Morecambe Offshore Windfarm: Generation Assets Examination Documents

The Applicant's Response to ExA's Written Questions 3

Document Reference: 9.61

6 Liverpool Bay SPA with 2.4nm CPP1 WTG and OSP Aviation Buffer and 1.9nm Calder WTG and OSP Buffer

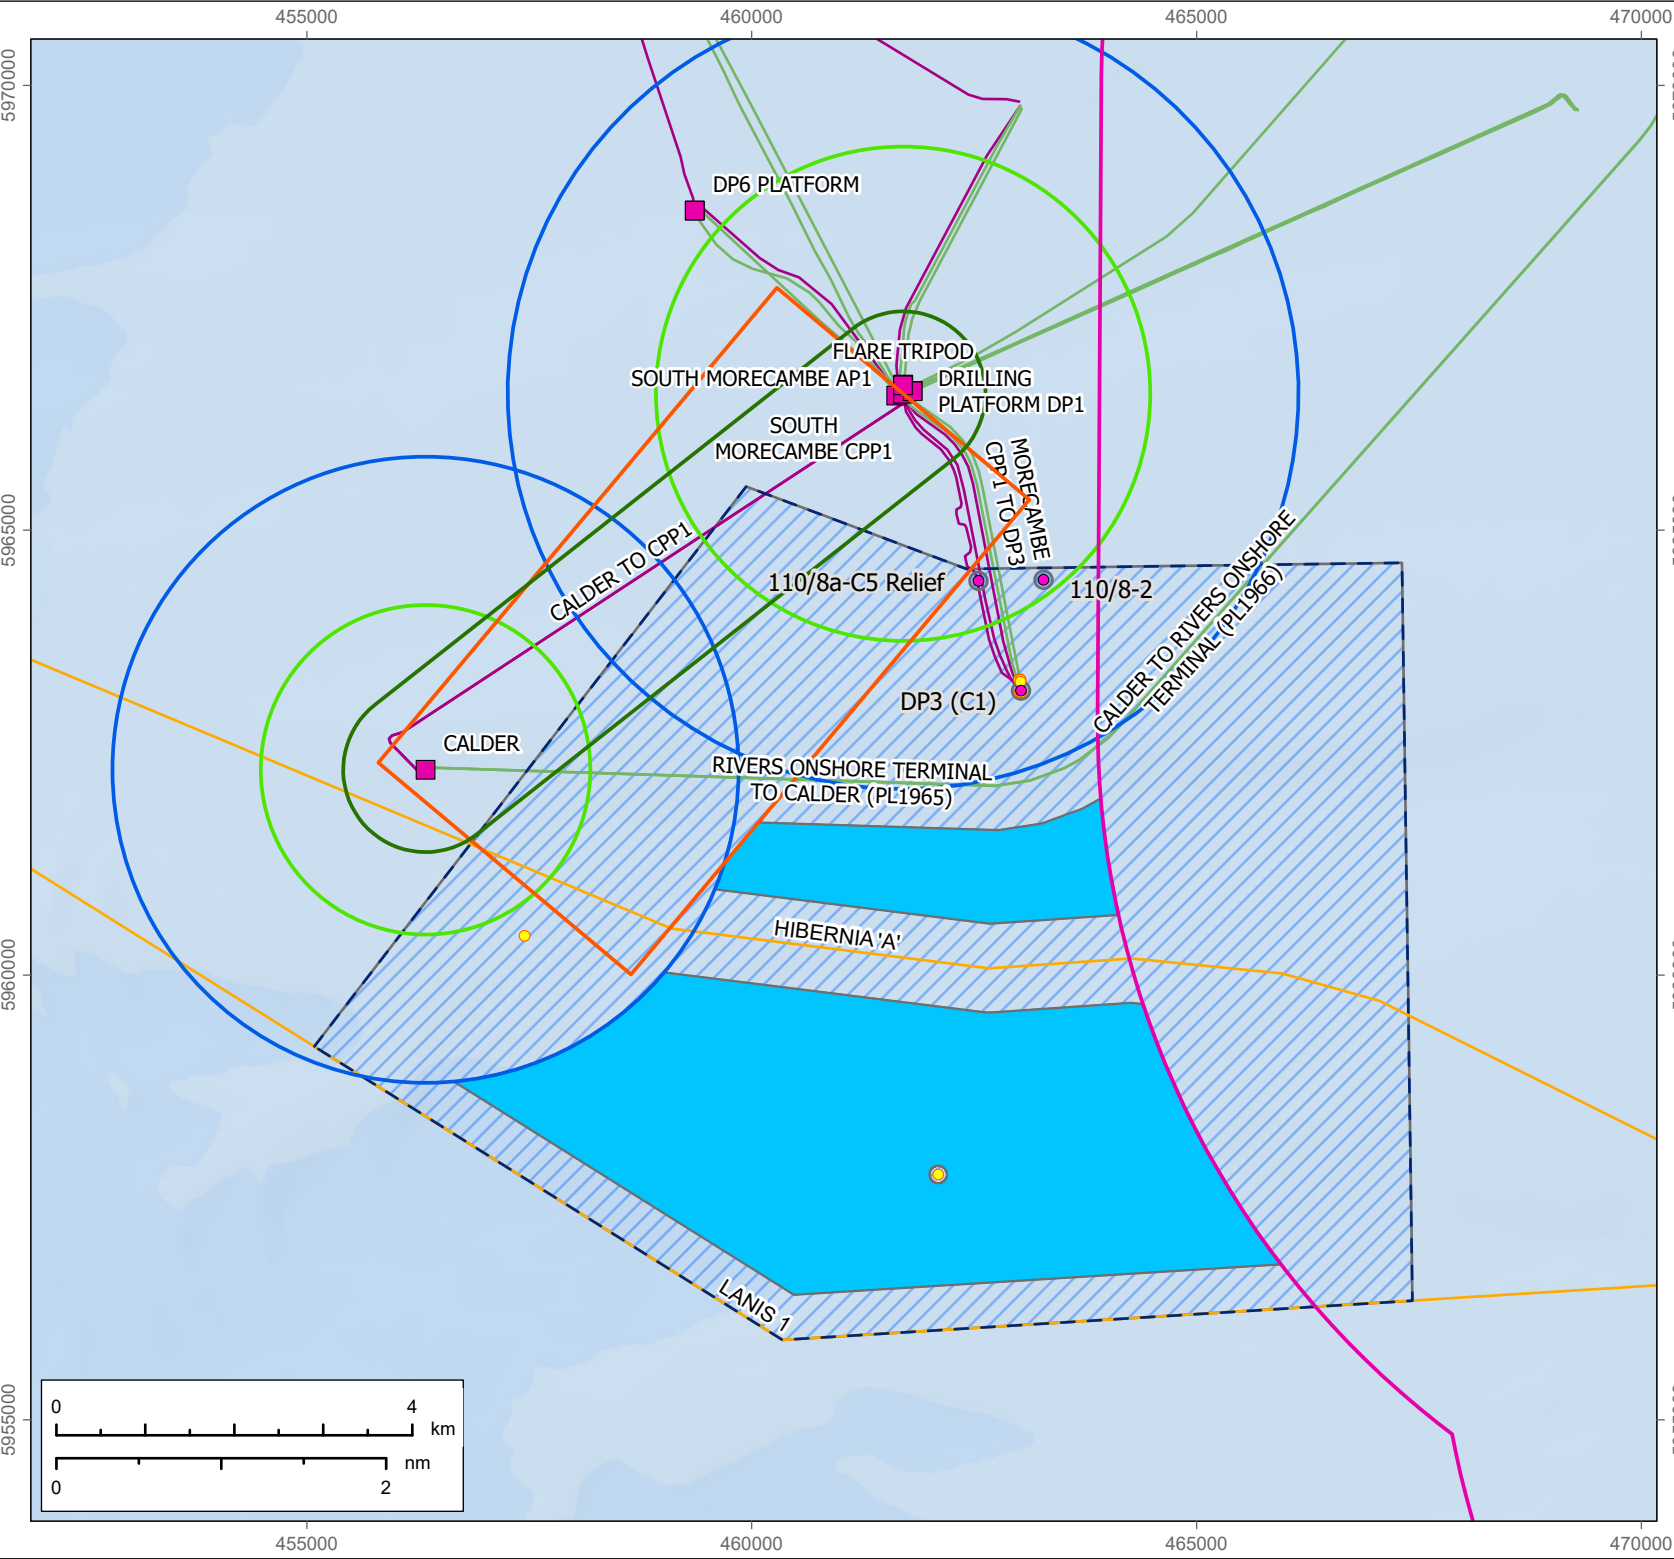
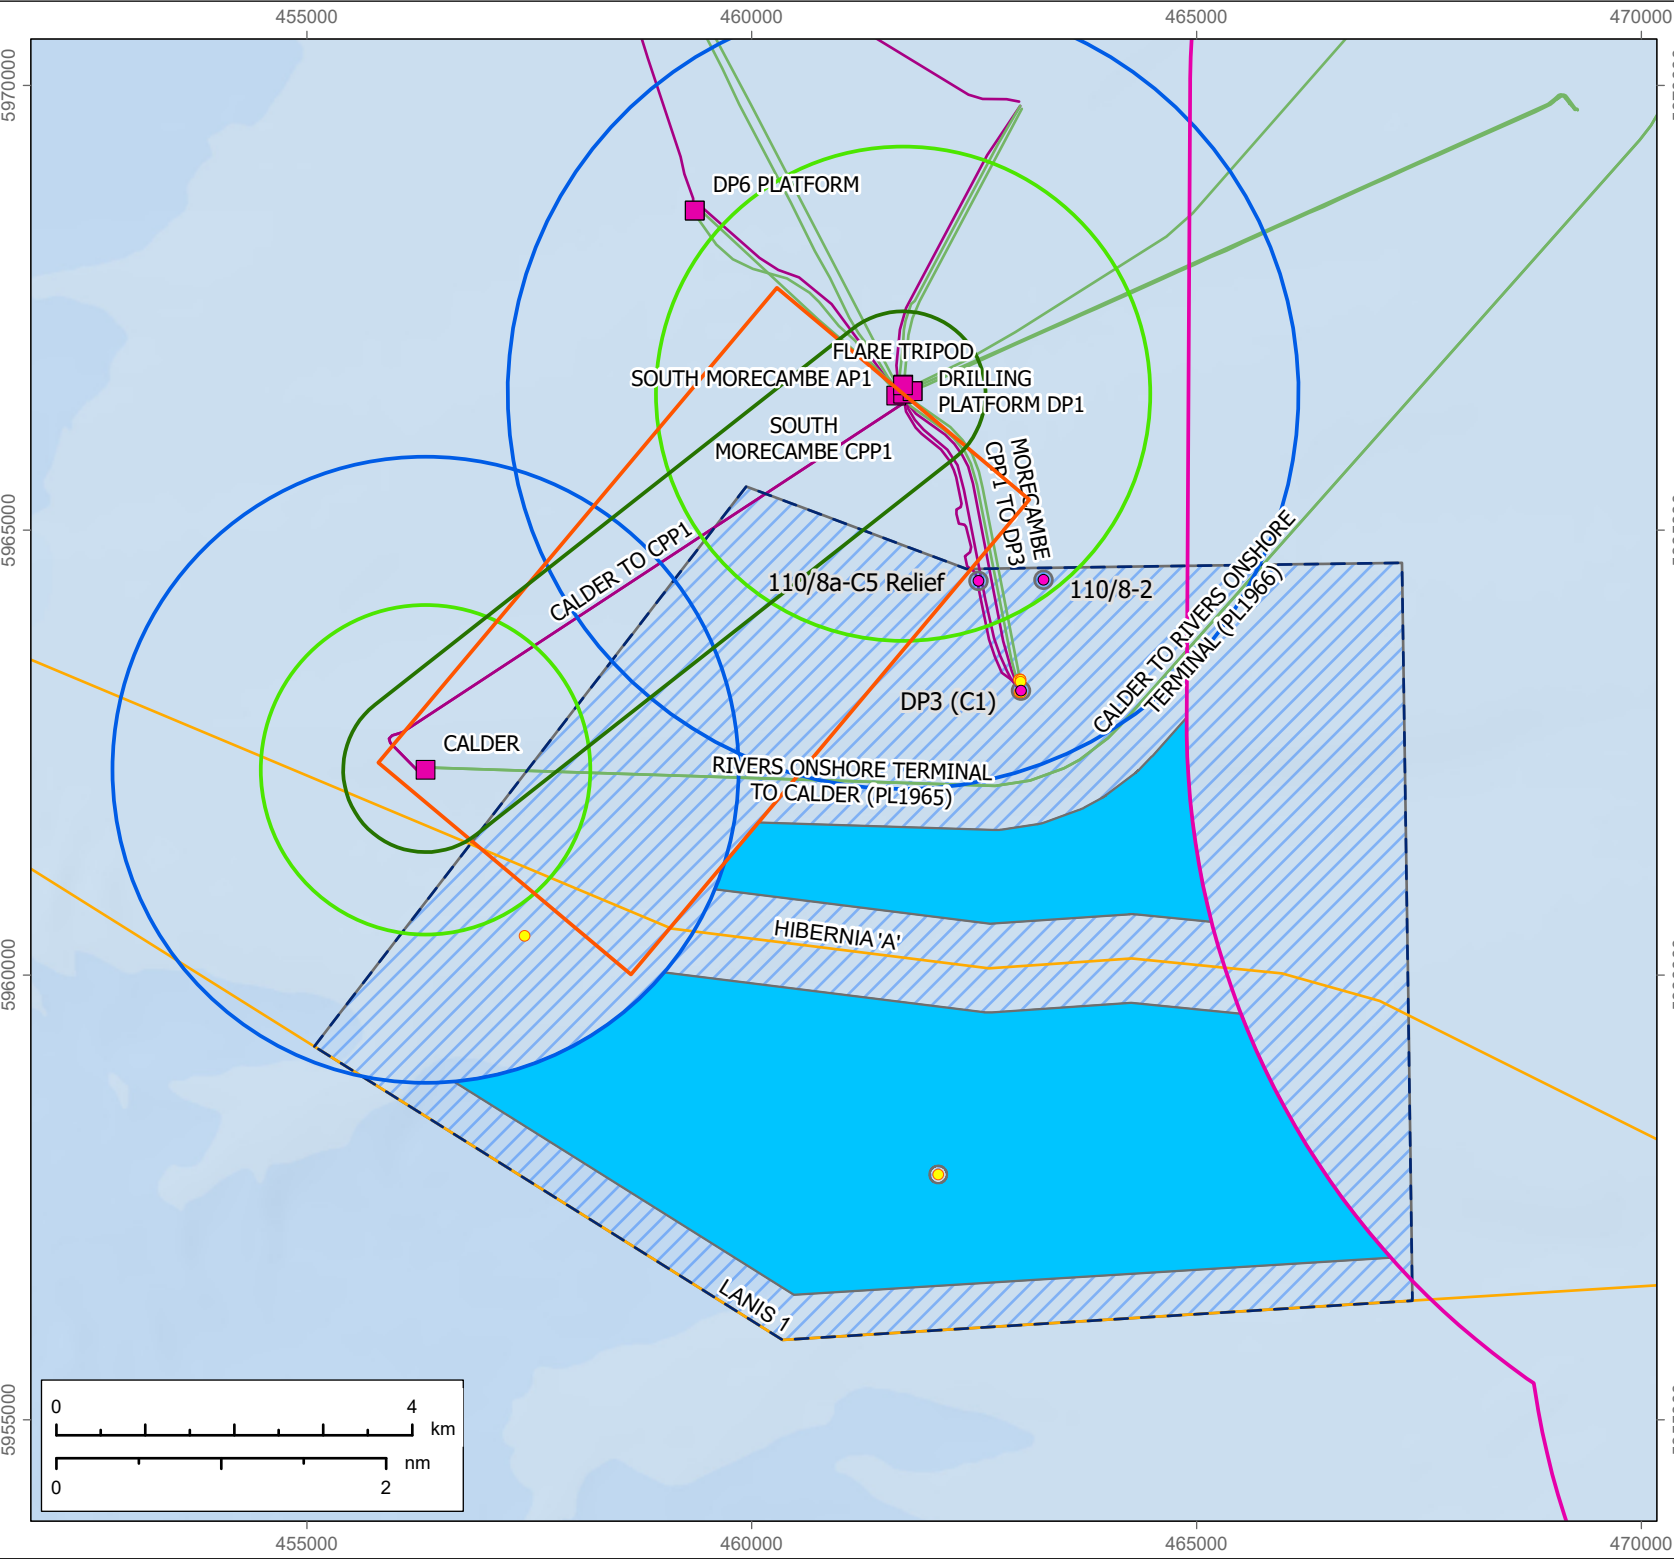
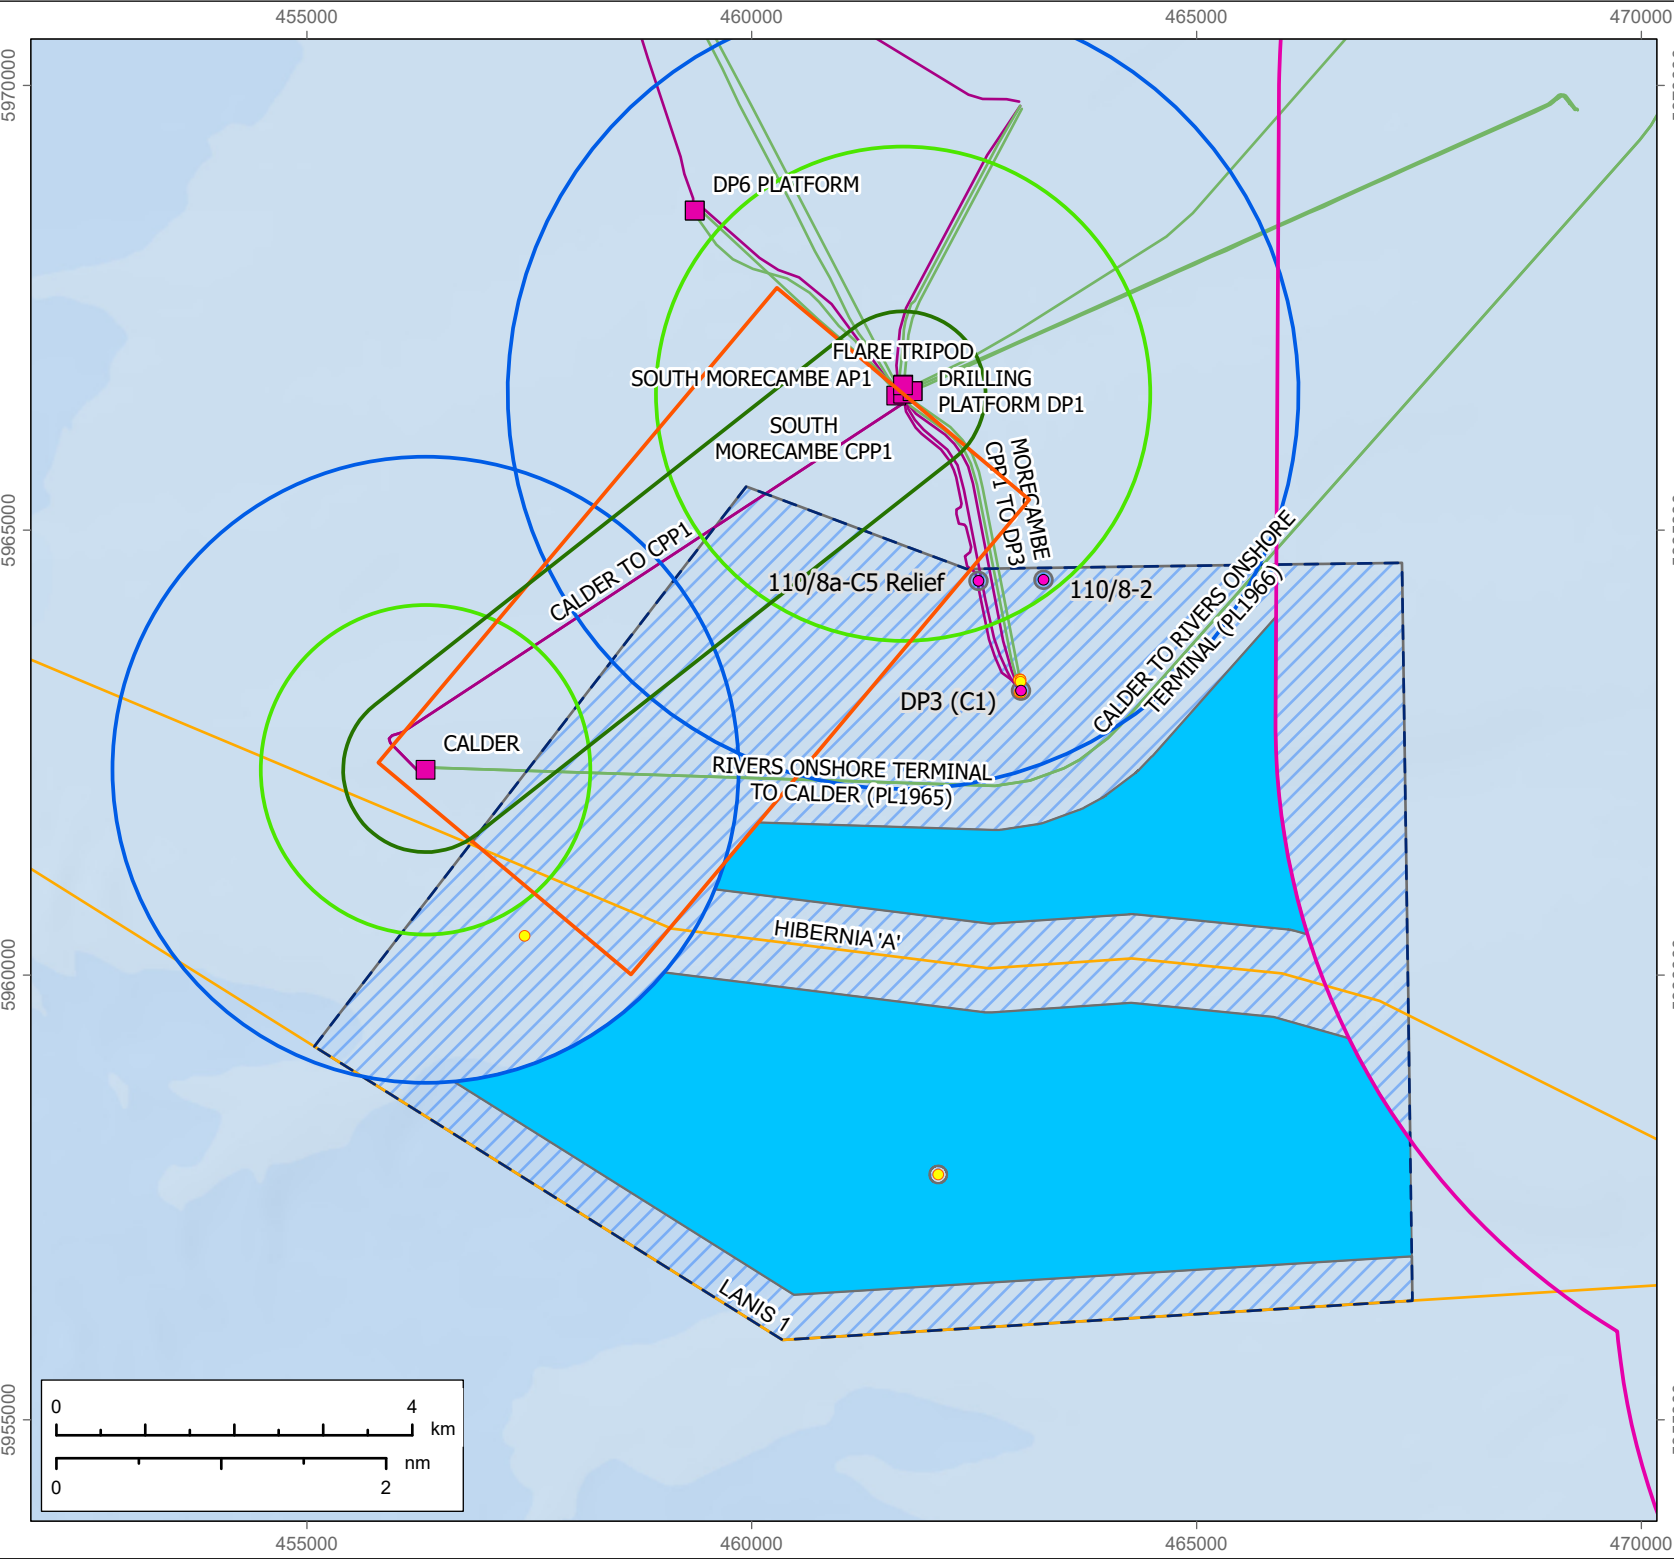
Ref.	Question to:	Question	Applicant's Response										
		<p>b) in Spirit Energy's response to ExQ2CAR5 at D5 [REP5-090] it advises a buffer distance of 1.9nm is the minimum acceptable requirement for safe landing and take-off in daytime VMC and for night VMC this distance would be 2.4nm. In light of this could the applicant provide plans for each alternative SPA buffer scenario in (a) plus each of the increased buffer scenarios from the Calder and CCP1 platforms as set out in the following table.</p>

<p>c) any additional comments or further information the applicant wishes to provide on the implications of each of the above scenarios (noting the applicant's previous response [REP5-070], EXQ2HRA3 and 2HRA6].</p> <p>The ExA is seeking a complete set of alternative scenarios shown on plans, so that, whatever the SoS may determine, if they felt it was appropriate they could include the relevant plan within any final DCO without having to revert to the applicant for that plan. Each should therefore have a different drawing number.</p>	<u>CPP1 WTG and OSP Aviation Buffer</u>	<u>Calder WTG and OSP Buffer</u>	1.9nm	1.9nm	2.4nm	1.9nm	1.9nm	2.4nm	2.4nm	2.4nm	
<u>CPP1 WTG and OSP Aviation Buffer</u>	<u>Calder WTG and OSP Buffer</u>												
1.9nm	1.9nm												
2.4nm	1.9nm												
1.9nm	2.4nm												
2.4nm	2.4nm												
3GEN4	The applicant	<p>Design Statement - Cabling</p> <p>Could the applicant please explain why (former) provision DC15 relating to use of the most direct/ efficient cabling</p>	<p>The Applicant removed the former provision DC15 as it considered that this was duplication of DC10. The Applicant has updated the Design Statement_Rev 04</p>
